An
Bord
Pleanála

Inspector's Report

ABP-314964-22

Development	Proposed development of a Circular Economy Campus and an Integrated Waste Management Facility
Location	Hollywood Great, Nag's Head, Naul, Co. Dublin, A41 YE92
Planning Authority	Fingal County Council
Applicant	Integrated Materials Solutions Ltd. Partnership
Type of Application	Application under section 37E of the Planning & Development Act, 2000 (as amended)
Prescribed Bodies	<ol style="list-style-type: none">1. Fingal County Council2. EPA (Environmental Licensing Programme)3. Eastern-Midlands Regional Waste Management Planning Office4. Inland Fisheries Ireland (IFI)5. Department of Housing, Local Government and Heritage (National Parks & Wildlife Service (NPWS))

Scale	1:500 @ A1 1:1000 @ A3	Project	INTEGRATED WASTE MANAGEMENT FACILITY AT HOLLYWOOD CIRCULAR ECONOMY CAMPUS
Created on	NOV 18	Title	LONG SECTIONS SECTION 1 - 1
Sheets	01 of 06	File Identifier	MDR1492-RPS-00-XX-DR-C-DG2007
Status	S3	Rev	P05

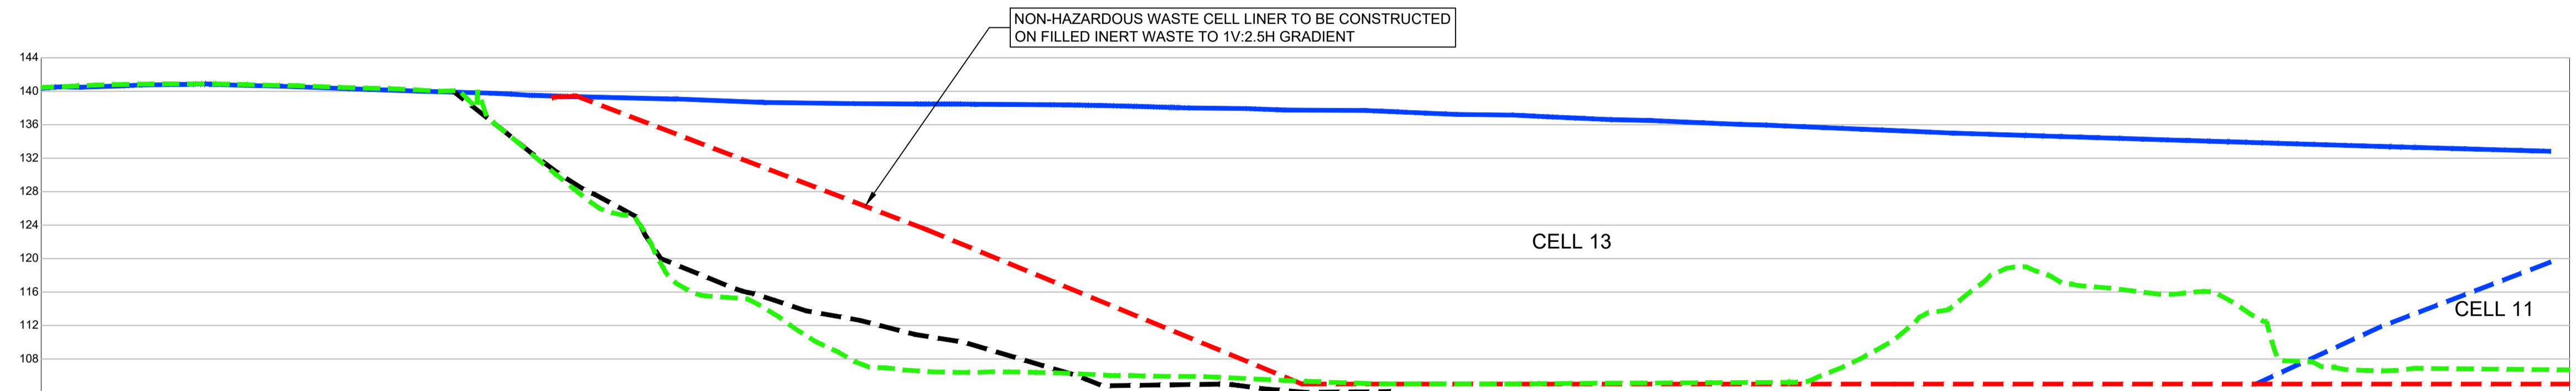
- Condition 1 – Final contours as per Drawing No. MDR-1492-RPS-00-XX-DR-C-DG2007 and upon restoration the site to be used for agricultural purposes.
- Condition 2 – Intake of waste material not to exceed 500,000tpa.
- Condition 4 – Implementation of mitigation measures in the EIAR and NIS.
- Condition 6 – Sub-condition (a) requires a stage 3 road safety audit and sub-condition (b) requires a special contribution €10,000 for signing and lining.
- Condition 7 – Submission of a Construction Management Plan and Construction Traffic Management Plan.
- Condition 8 – An archaeological geophysical survey to be carried out to the north east of the site in the location of the proposed attenuation pond and an
